24 January 2022

**SSD-9601 (MOD 1) – 780 WALLGROVE ROAD, HORSLEY PARK – UPGRADES
TO FACILITY AND INCREASE BRICK MANUFACTURING CAPACITY**

The SSD Mod Report has been reviewed and no objections are raised however request the following traffic matters be considered prior to determination.

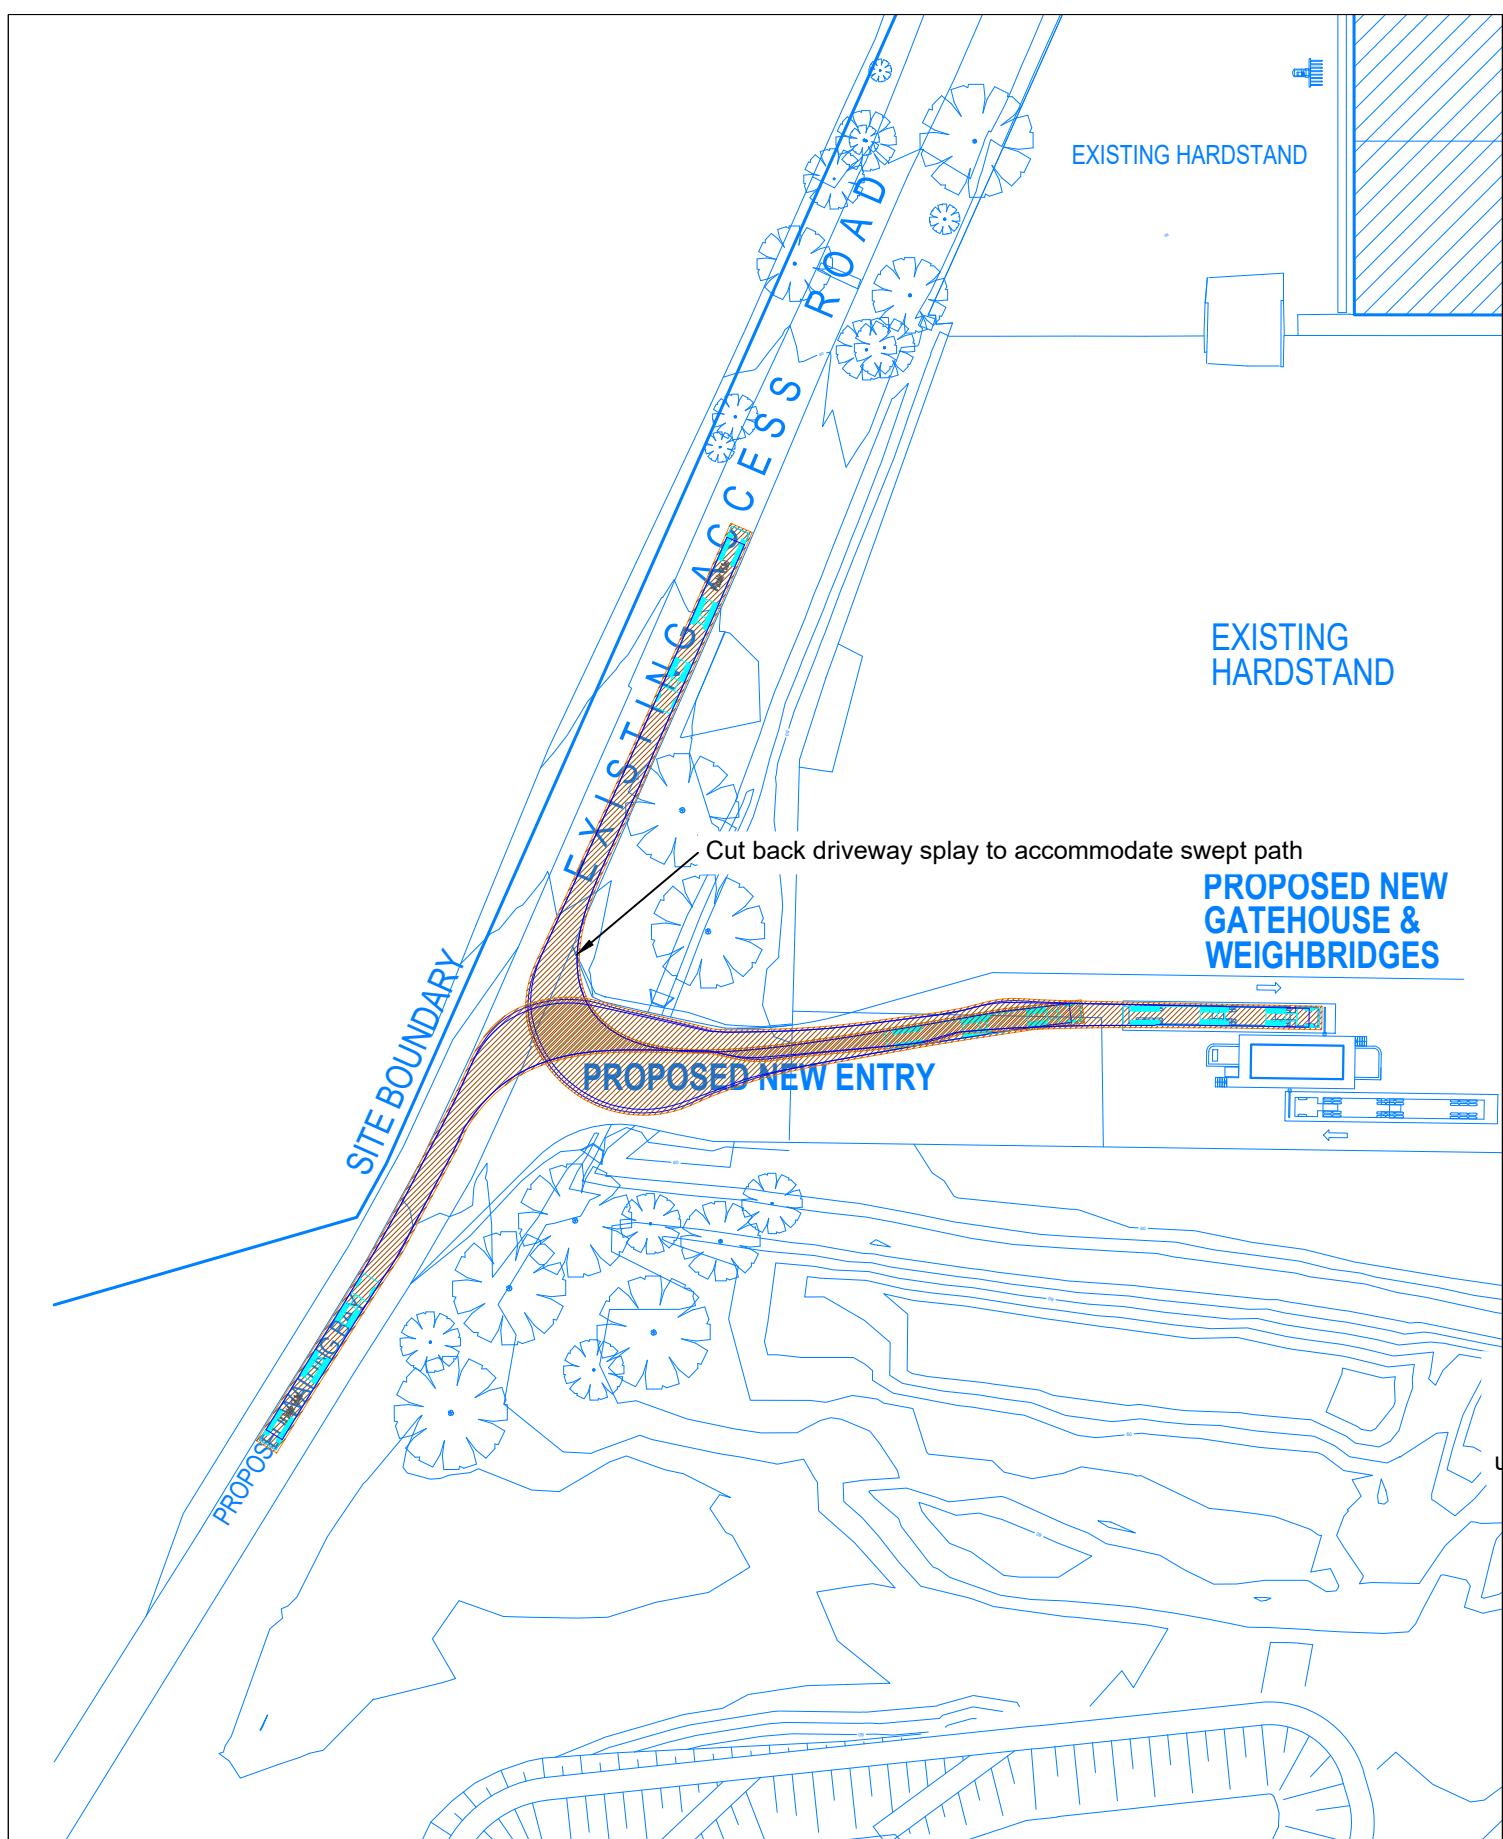
- Swept path diagram (AG04) showing heavy rigid vehicle manoeuvring through the fire access road to drive up the ramp would conflict with passenger vehicles accessing the car park. The potential conflicts between heavy vehicles and passenger vehicles shall be addressed and additional information shall be submitted to Council for assessment;
